RE: Existing Tank Application # BRES2409-0056

An attempt was made to evaluate your property for the purpose of issuing an existing tank permit. The evaluation could not be completed for one or more of the following reasons.

Existing Septic Tank

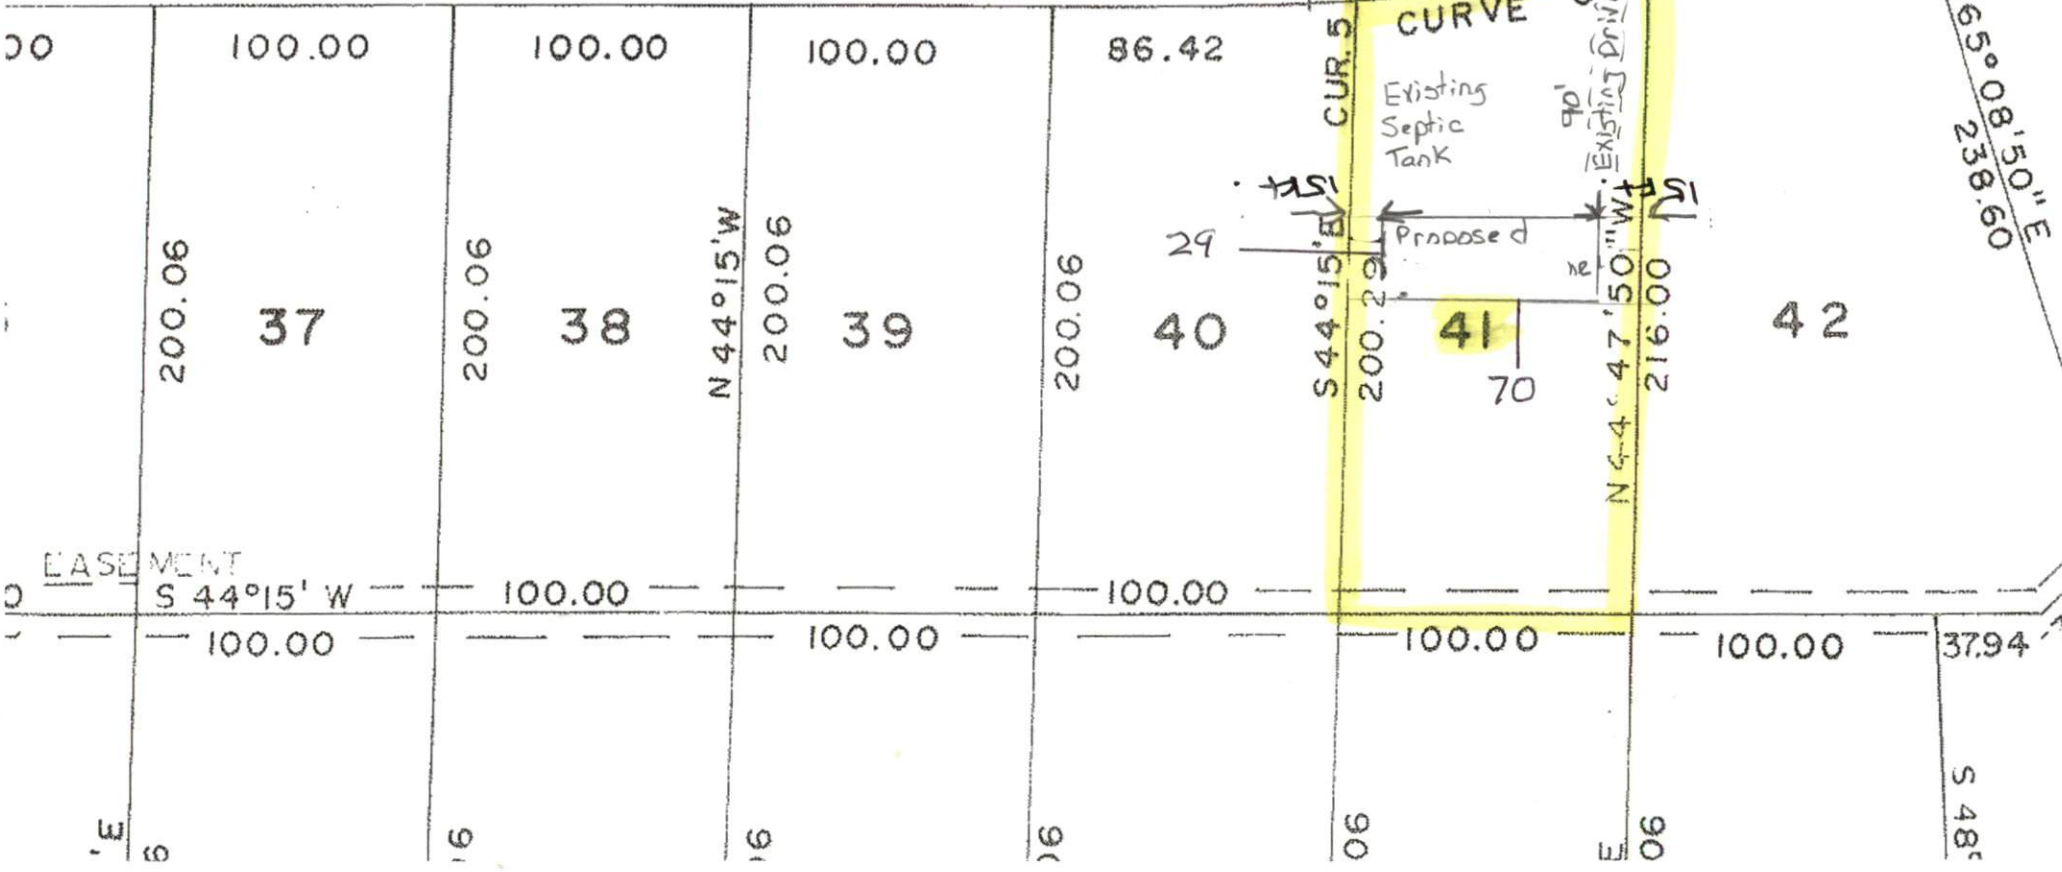
- 1. Uncover Outlet lid on septic tank and break seal. (\$25.00 fee incurred).
- 2. Have system pumped out
- 3. Replace Sanitary T
- 4. **Other – Will need to move house forward to get if off the drain lines or complete a septic system relocation application. All 4 property irons need to be exposed.**
